Appeal Decision

Appeal Ref: APP/T2350/W/23/3325434

Land adjacent to Miles Hill, Moor Lane, Billington BB7 9JH

- The appeal is made under section 78 of the Town and Country Planning Act 1990 against a refusal to grant approval required under Schedule 2, Part 3, Class Q of the Town and Country Planning (General Permitted Development) (England) Order 2015 (as amended) (the GPDO).
- The appeal is made by Mr Tom Procter against the decision of Ribble Valley Borough Council.
- The application Ref 3/2023/0226, dated 15 March 2023, was refused by notice dated 5 May 2023.
- The development proposed is conversion/redevelopment of two agricultural buildings into 2 dwellings.

SHEET: BARN 2 EXISTING AND
PROPOSED PLANS AND
ELEVATIONS

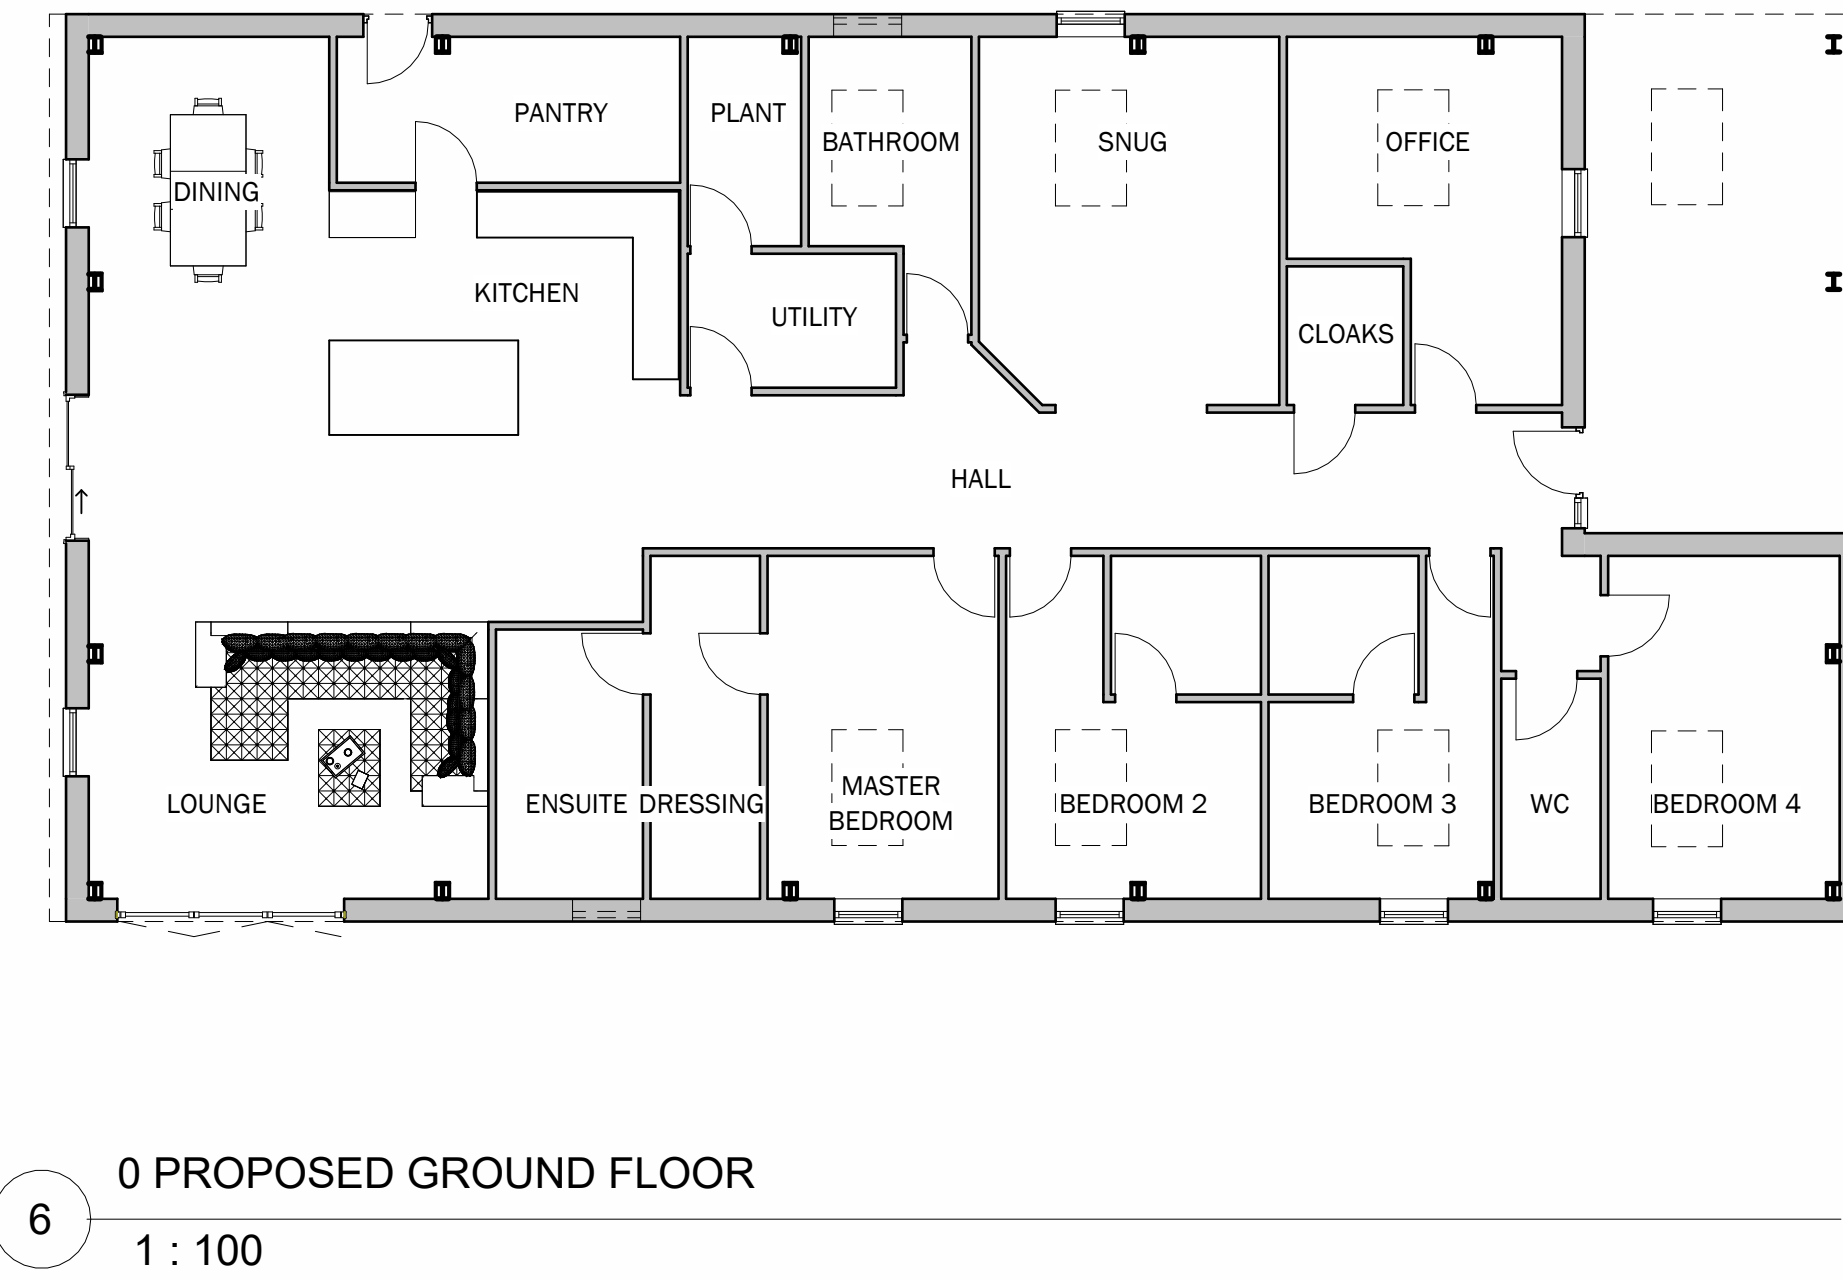
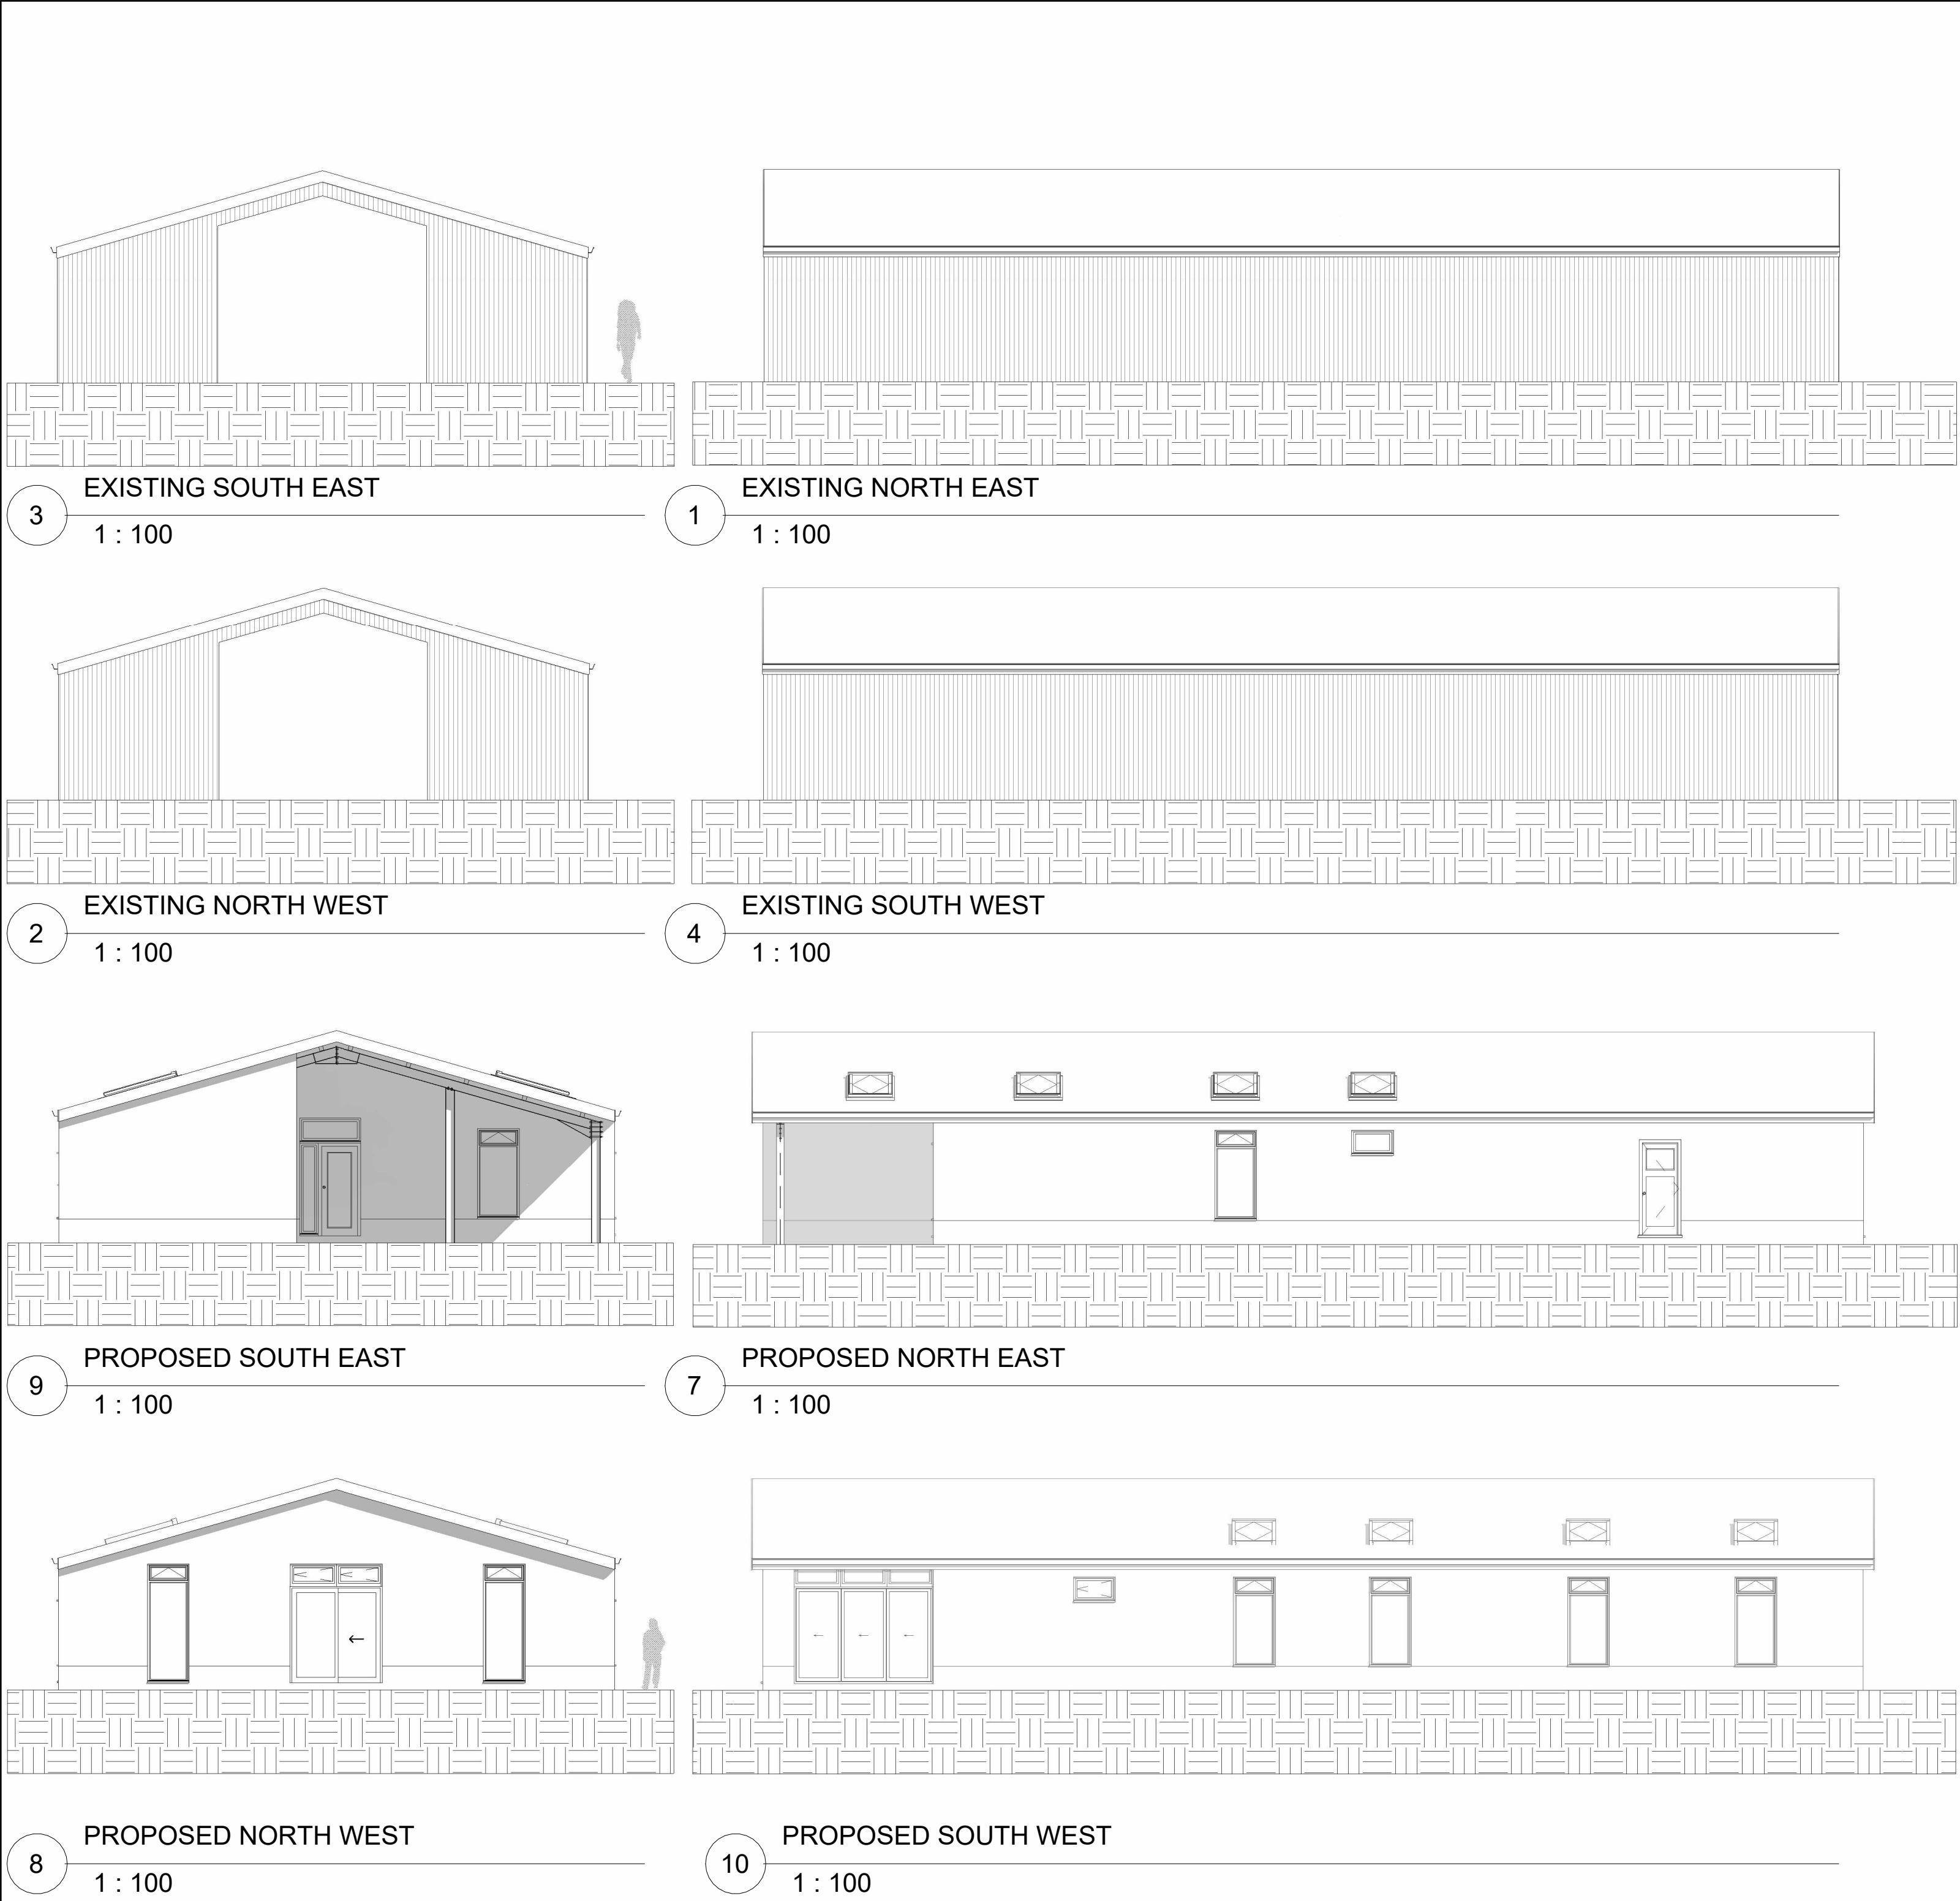
14. The main access to Barn 2 would be via a door in its recessed canopied south east gable end. Taking into account the size of the proposed canopied area and that the existing access is provided by an internal ramp, the change in levels could be similarly managed by a small scale internal intervention within the building envelope which could include raising of internal levels, steps or ramp. This could be secured through the imposition of a planning condition. The section of retaining wall between the buildings would appear to serve little functional purpose in terms of the residential use of the buildings, notwithstanding it may be a more aesthetically pleasing solution than the existing agricultural hardstanding. For these reasons, I find that the buildings could be converted and function as dwelling houses without the external groundworks proposed. The ground works and the retaining wall are not demonstrably reasonably necessary for the buildings to be converted.

21. Compared to the earlier scheme, the size of some of the elevation openings has been reduced. However, irrespective that the rooflights and openings may reflect the proposed internal layout, there would still be a large number of new domestic openings and extensive repositioning of openings. While the existing large gable end openings may not be historic or traditional cart door openings, they do contribute to the agricultural character and the interpretation of the buildings. In contrast, the proposed domestic openings in the gable end elevations would not reflect or respect the scale, number or position of the existing relatively simple agricultural openings. I note the appellant's concerns in relation to the potentially greater adverse visual impact if large openings were to be retained. Irrespective, the large number of domestic openings, and that are poorly-related to the existing arrangement, would contribute to the erosion of the functional appearance of the buildings.

22. The proposed rooflights would be more regularly arranged, but they would be increased in number. While there are a large number of existing rooflights, these appear to be corrugated plastic flush with the corrugated roof of the agricultural buildings. In contrast to these existing relatively unobtrusive rooflights, and by virtue of their number, domestic proportions and style, the proposed rooflights would be conspicuous to the detriment of the utilitarian appearance of the buildings. The appellant would be amenable to the imposition of a planning condition to control the design and appearance of the rooflights. However, I am not satisfied that this would be sufficient to mitigate the visual harm arising from the totality of the proposal.

24. The agricultural buildings are visible from around the highway access and from locations along the road. The nearby public right of way (the FP) affords clear views of the north east side elevation of Barn 1. Barn 2 is partly screened from the FP by Barn 1, but it is also partly visible and there are views of the north west gable ends of both barns from the FP. Therefore, notwithstanding local topographical variation and the distance to settlements, the proposal would be visible from locations in the surrounding area. The buildings would also be conspicuous overnight due to light spill from the numerous glazed openings including rooflights and at times of year when trees and hedges are not in leaf.
